Arun District Council
Arun Civic Centre
Maltravers Road
Littlehampton
West Sussex BN17 5LF
Planning & Building Control General Enquiries
Tel: (01903) 737756 Fax: (01903) 730442
Dx: 57406 Littlehampton
Minicom: 01903 732765
e-mail: planning@arun.gov.uk
website: www.arun.gov.uk/planning

Application No: FG/135/21/HH
Site Address: 23 Ocean Drive Ferring BN12 5QN
Description of works: Conversion of roofspace to habitable use to a chalet bungalow to include a flat roof dormer

Thank you for your internet representation made on 15th September 2021 which has been recorded as an objection with the comments as follows:

Side Elevation (South East Facing)
(Scale 1:100)

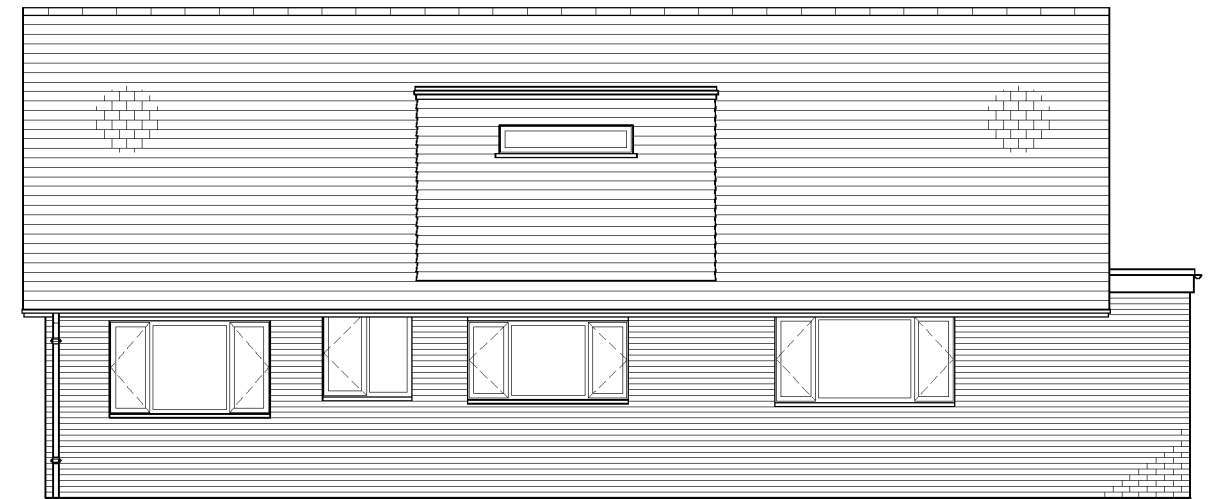
In relation to the above proposed development work. This property is next door to us. The proposed dormer window on the southern section of the roof is to have a full sized window that will directly overlook our property, being only 7m from our Northern side wall.

The dormer window will be able to look right into our lounge and kitchen, therefore considerably impacting on our privacy and making us feel overlooked. Mr Taff has previously made contact with us over this proposal and agreed to change this window design to a small high letterbox style window which will still allow light in, but is a compromise for our privacy. Mr Taff has assured us that this change would be submitted before any decision was made. To date this has not appeared on the planning site, hence our objection.

In conclusion. We feel that the plan for the Southern Dormer is invading our privacy and our right to a private life under Article 8 of the Human Rights Act. We would withdraw this objection if the proposal is amended as above.
